# COMPLETED 10/01/08 DRB CASE ACTION LOG (SITE PLAN BUILDING P.)

Project # 1007255

Project Name: VISTA GRANDE ADDITION UNIT 1

SUBJECT: Project # 1007255

Conceptual Site Plan

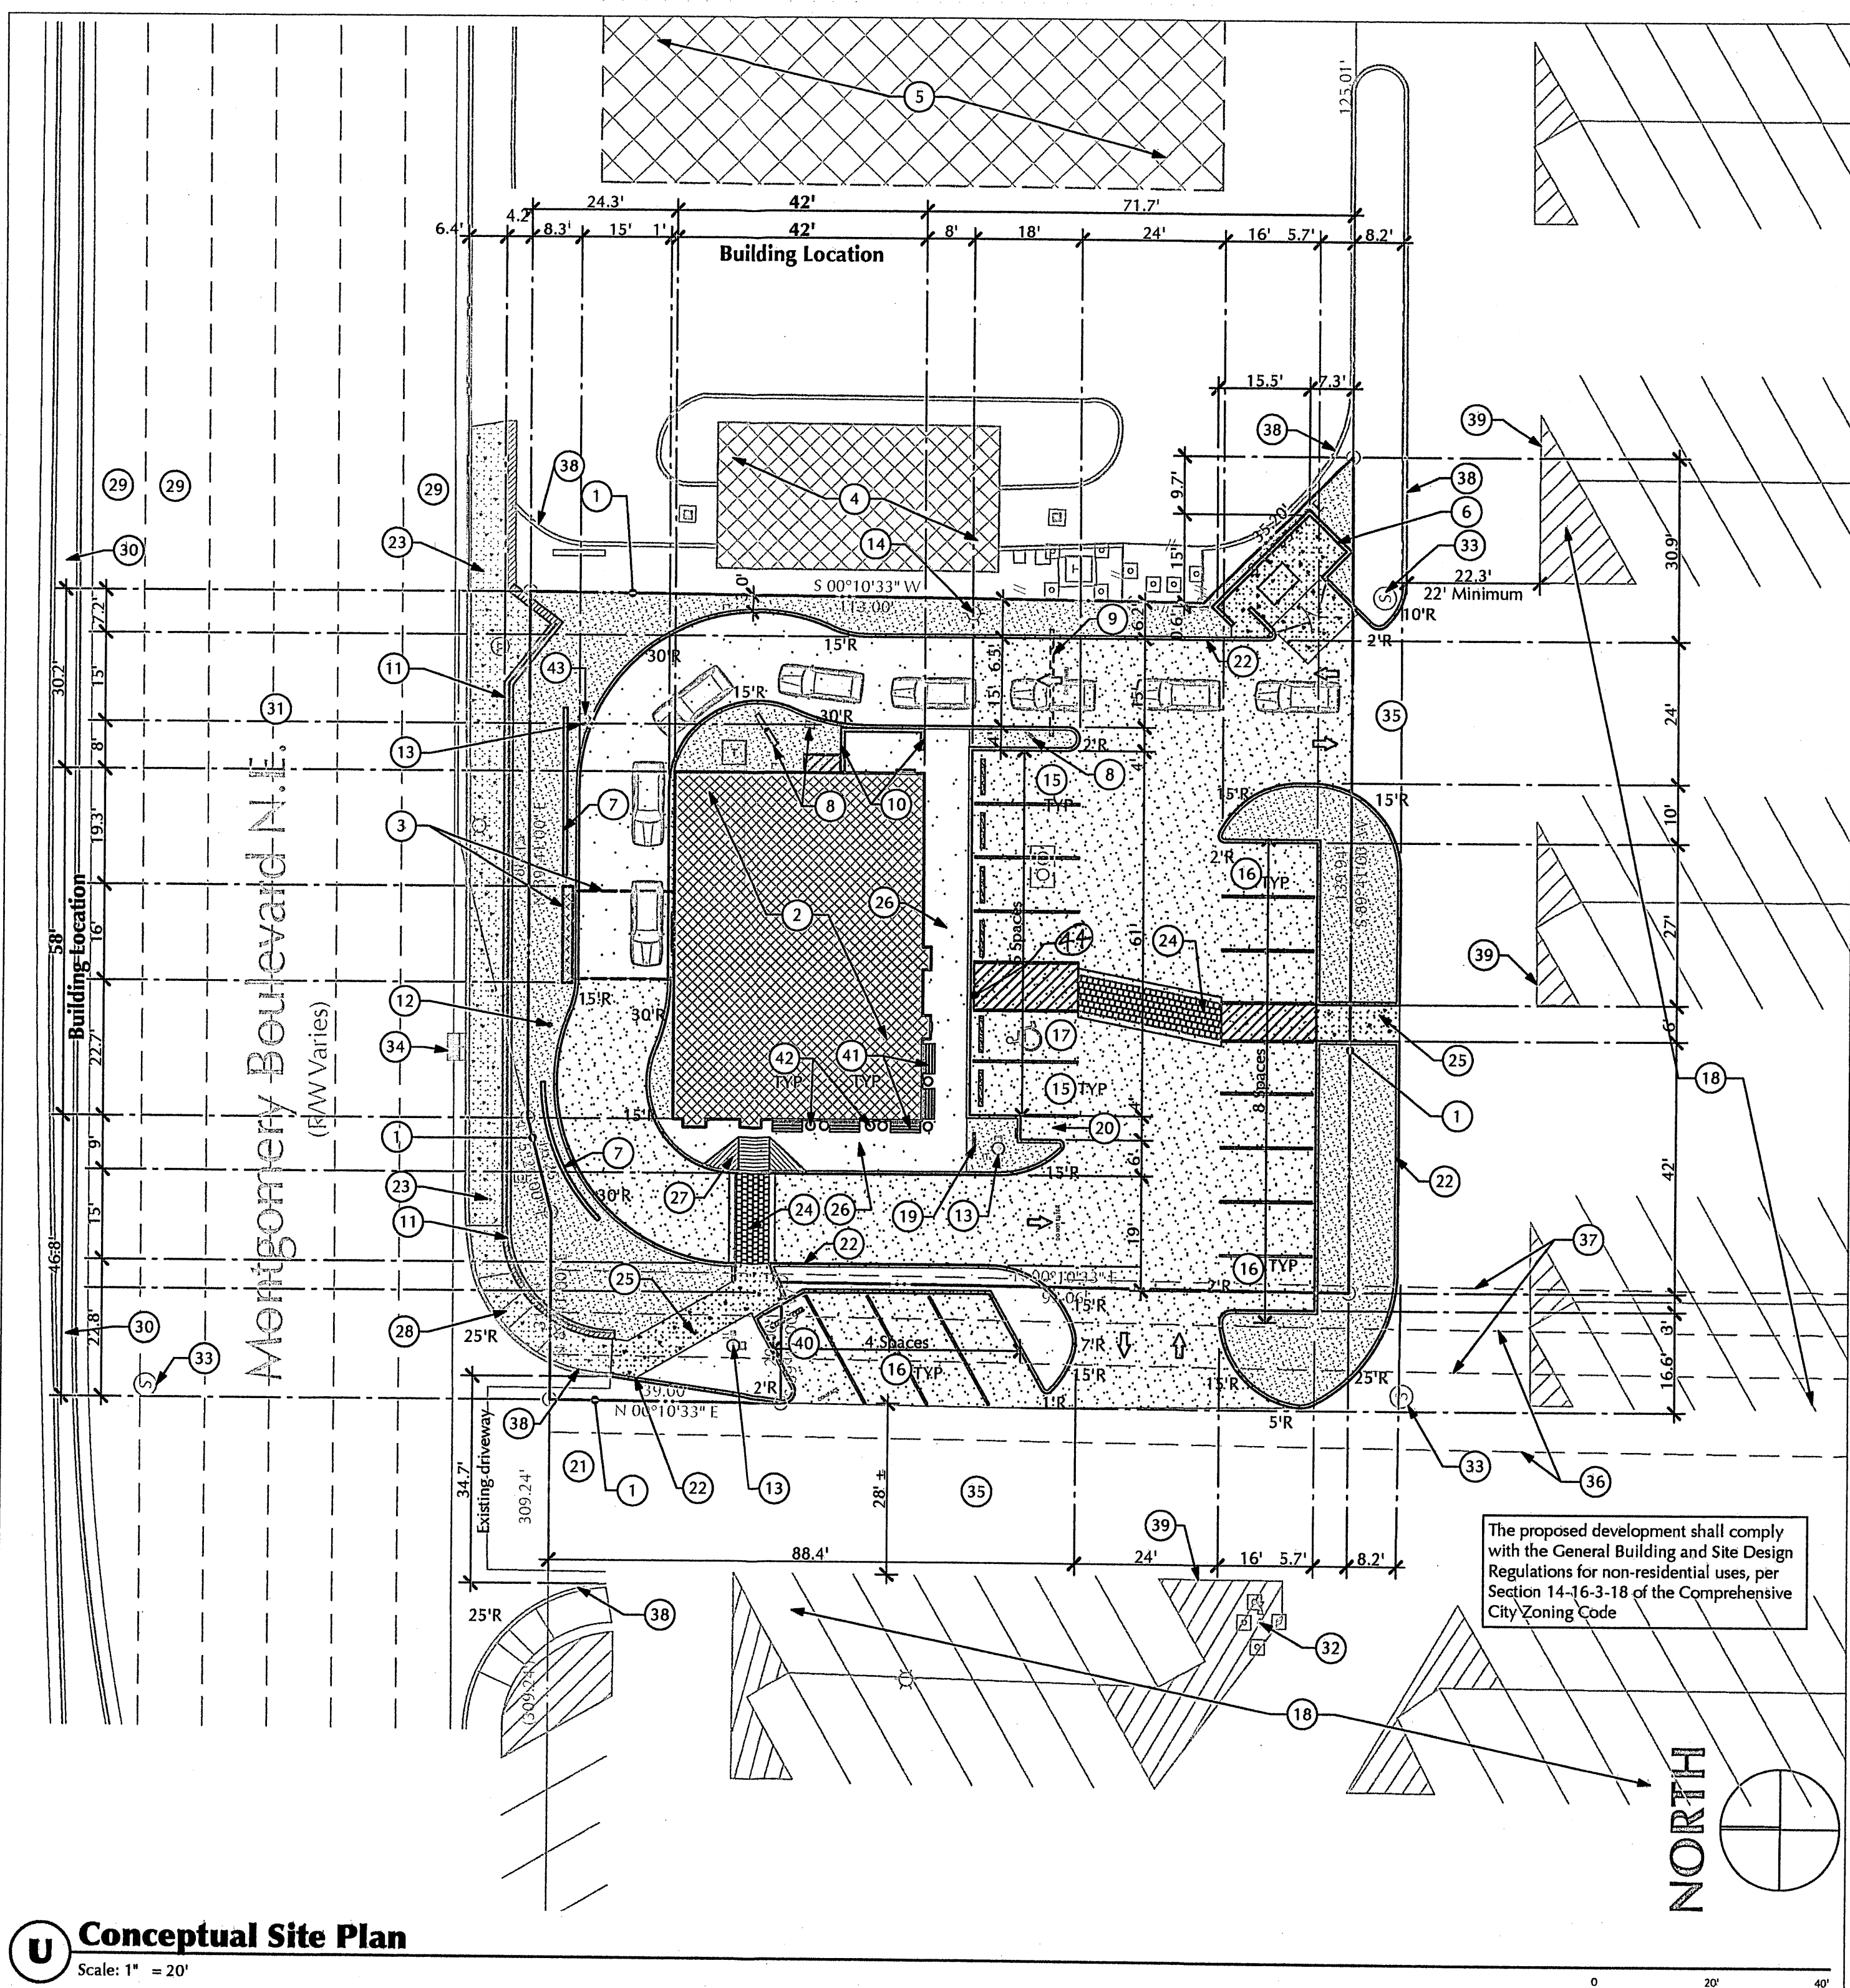
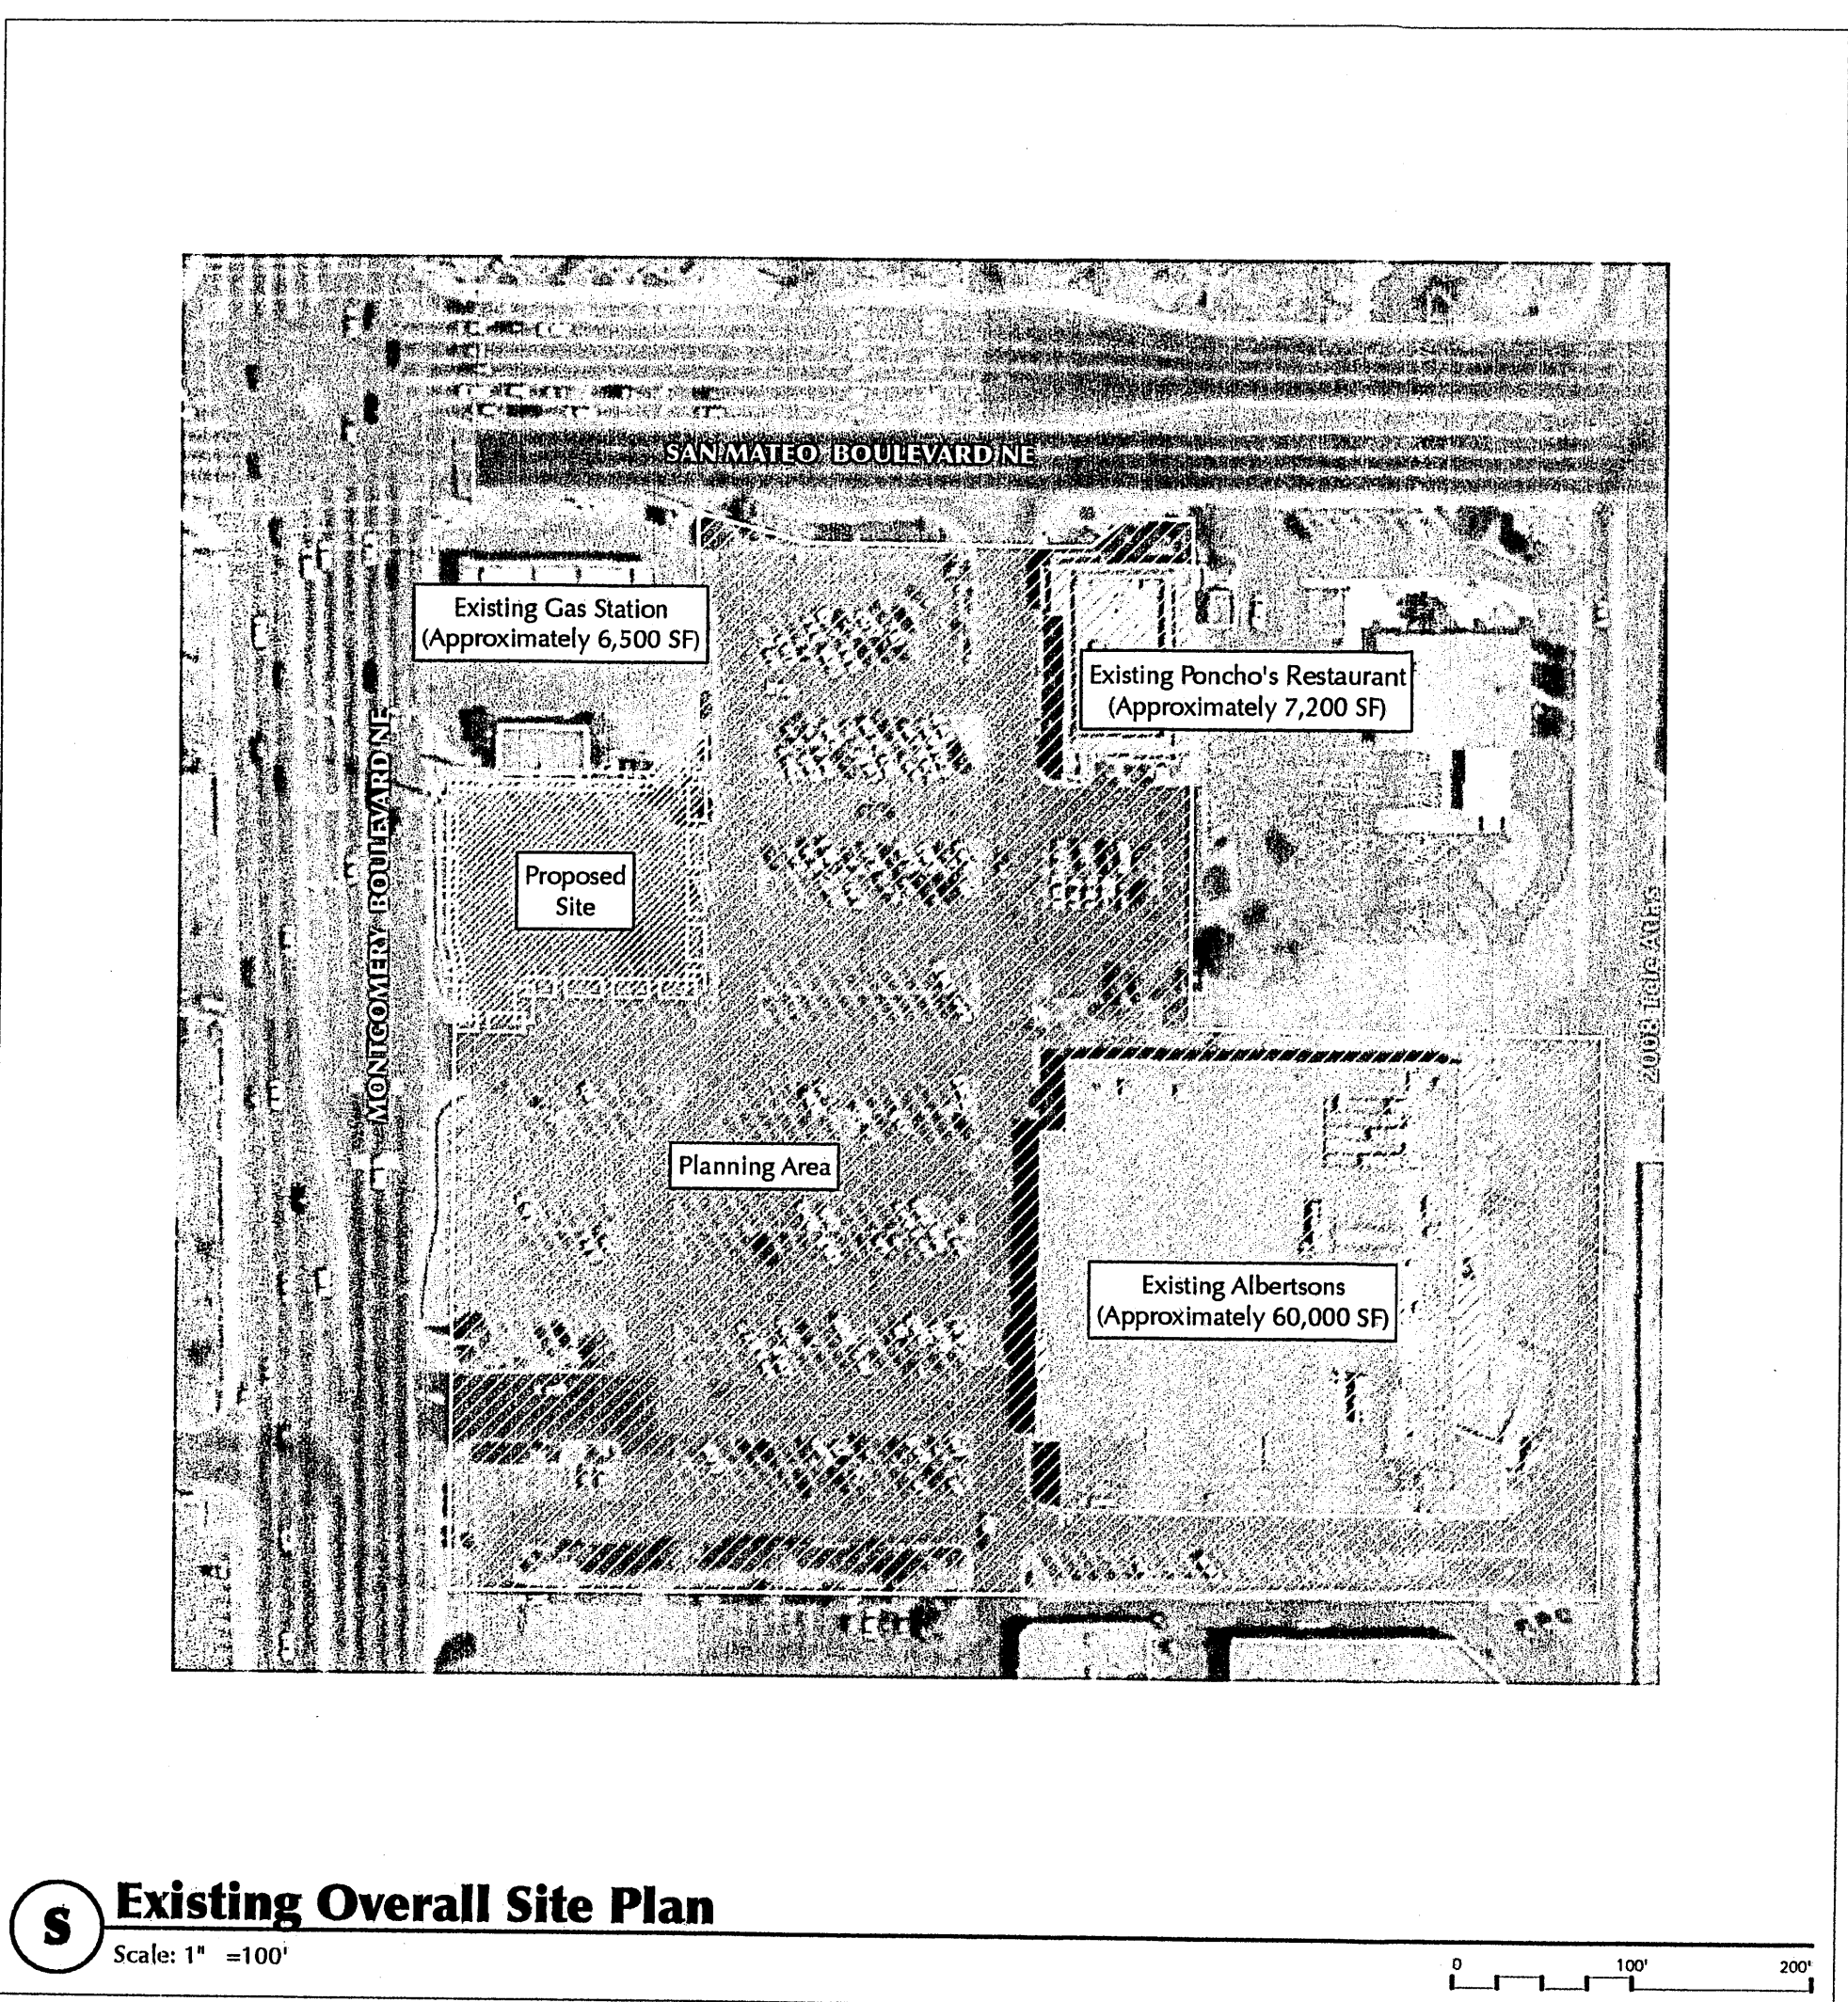
TRANSPORTATION: - see comments  
- Key Note 25 to state 6 foot SW

Condition #6 requires that proposed 4 foot wide sidewalks and 4 foot wide stamped concrete crosswalks shall be a minimum of 6 feet wide to ensure better pedestrian connectivity and to allow for better wheelchair access. The stamped concrete crosswalks have been widened to 6 feet, but the proposed sidewalk (keyed note # 25) is still listed as 4 foot wide.

SHEET
SDP-6
6 OF 6

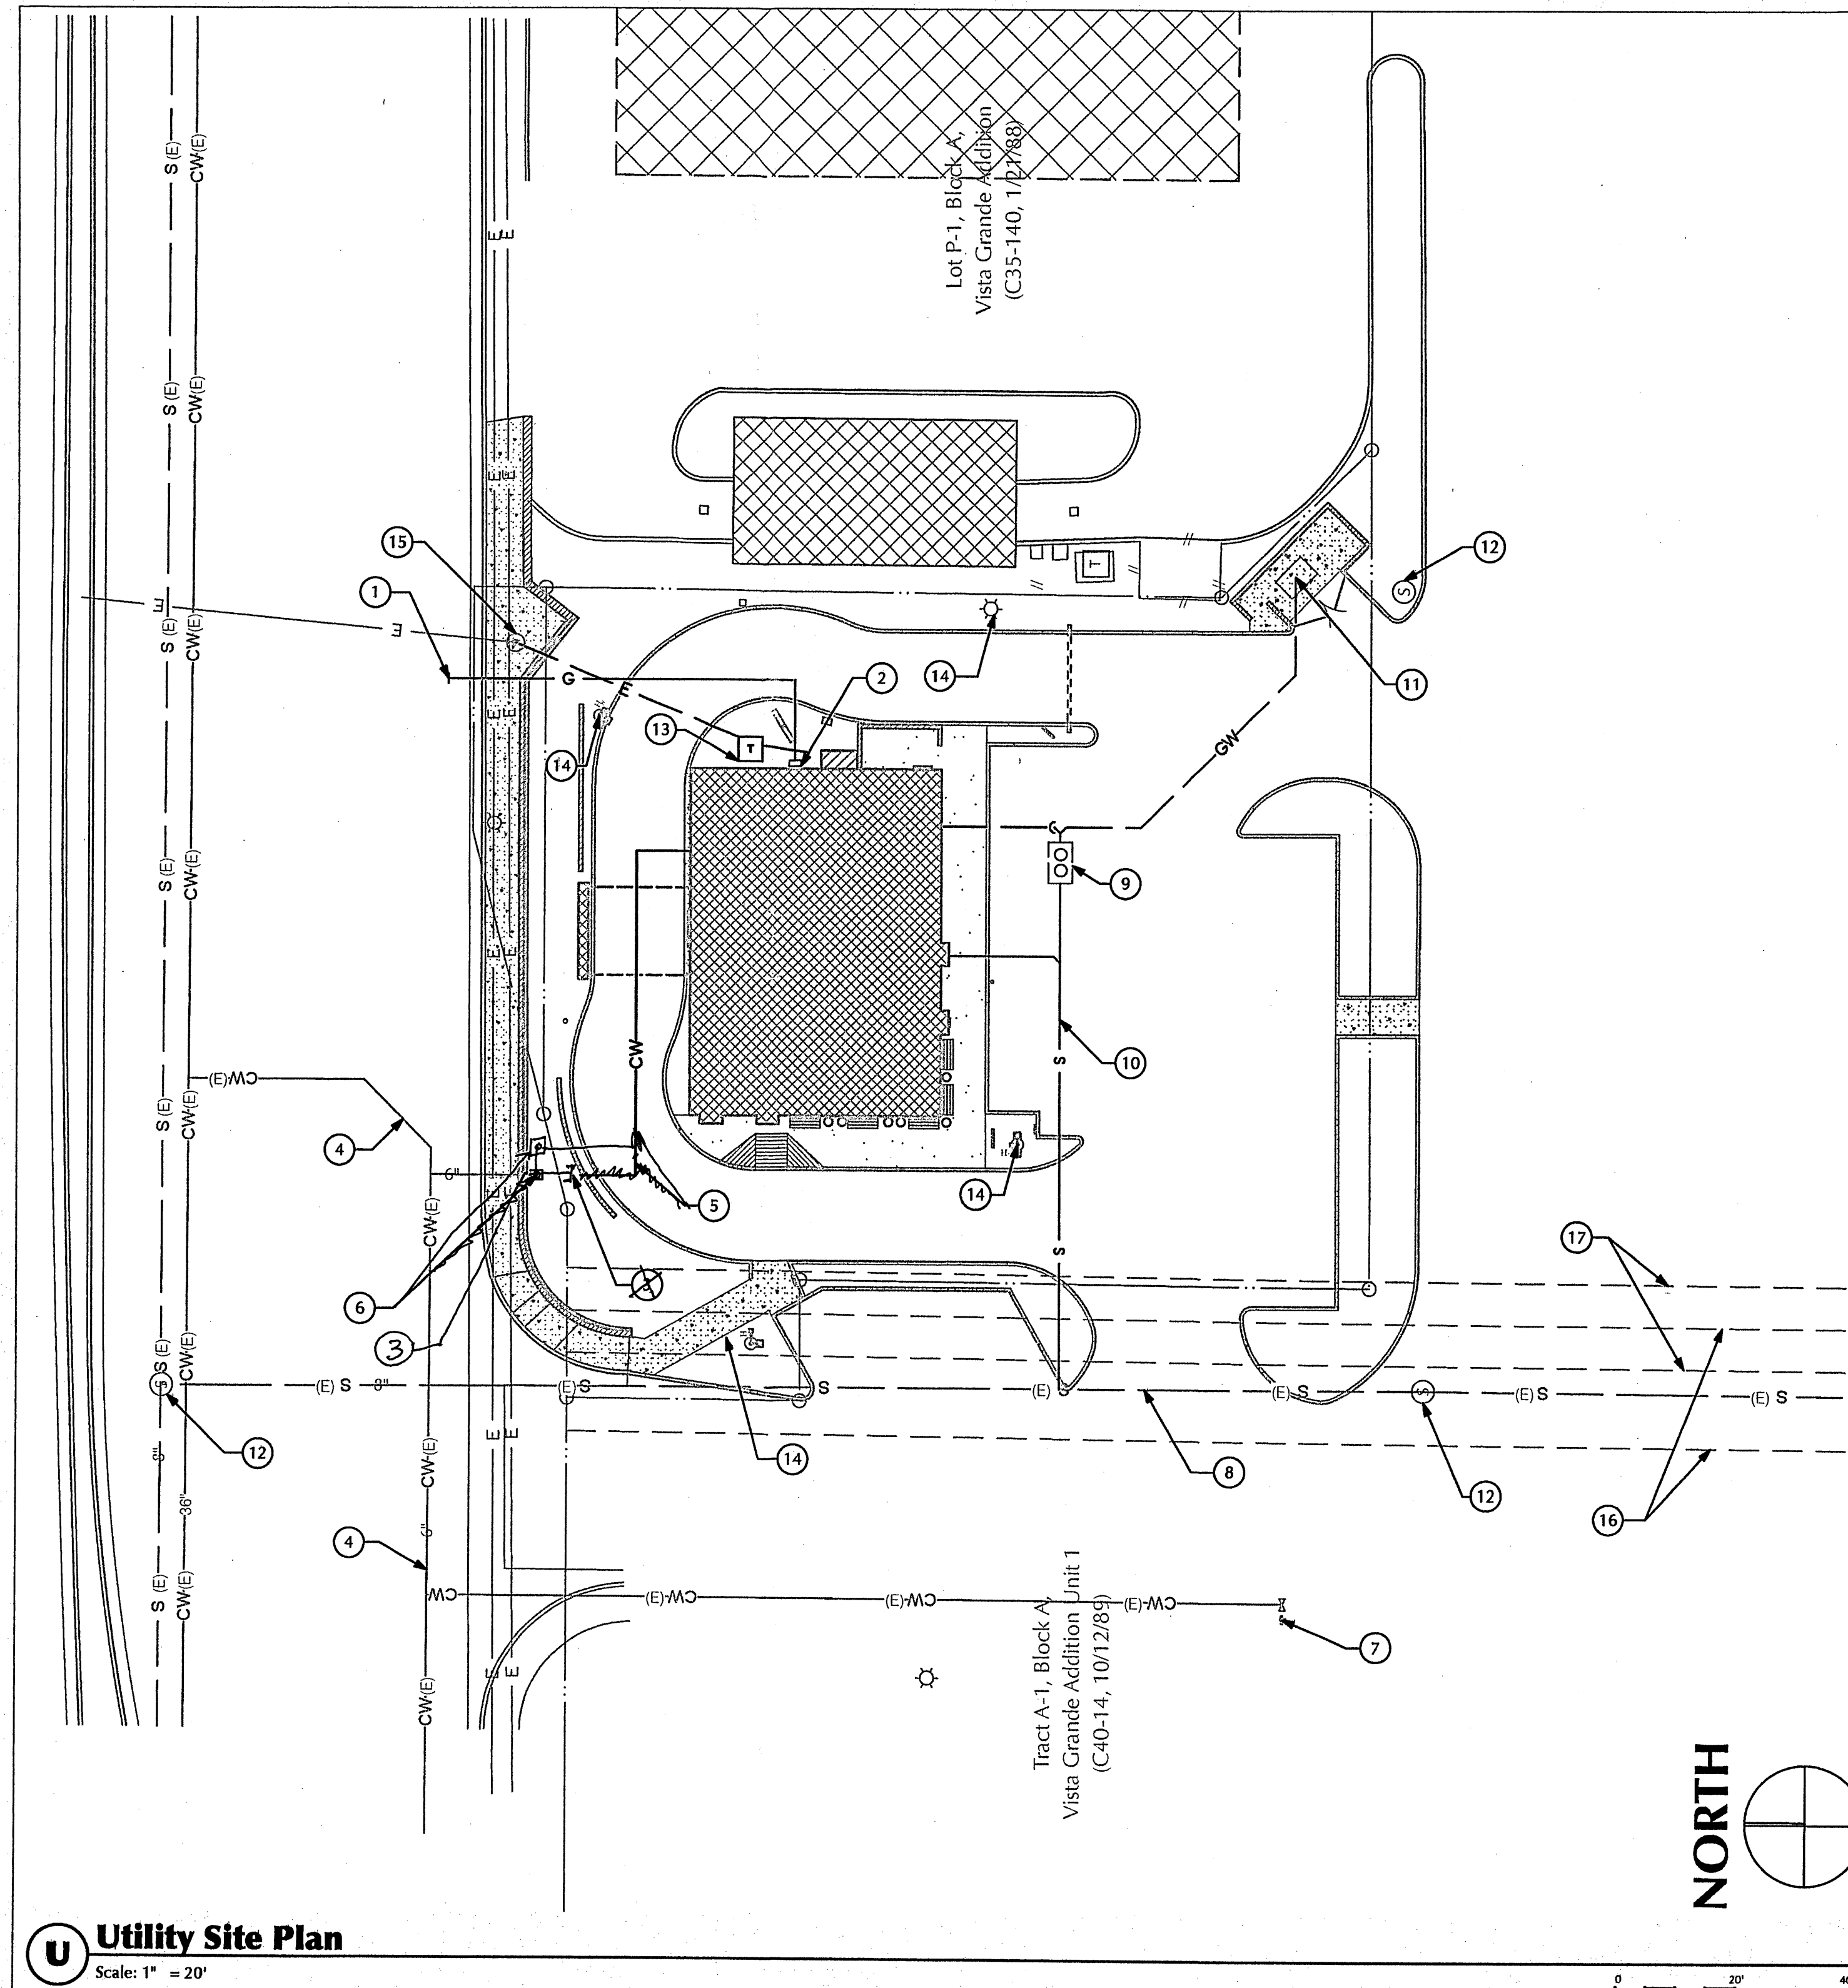
UTILITIES: - revise utility plan
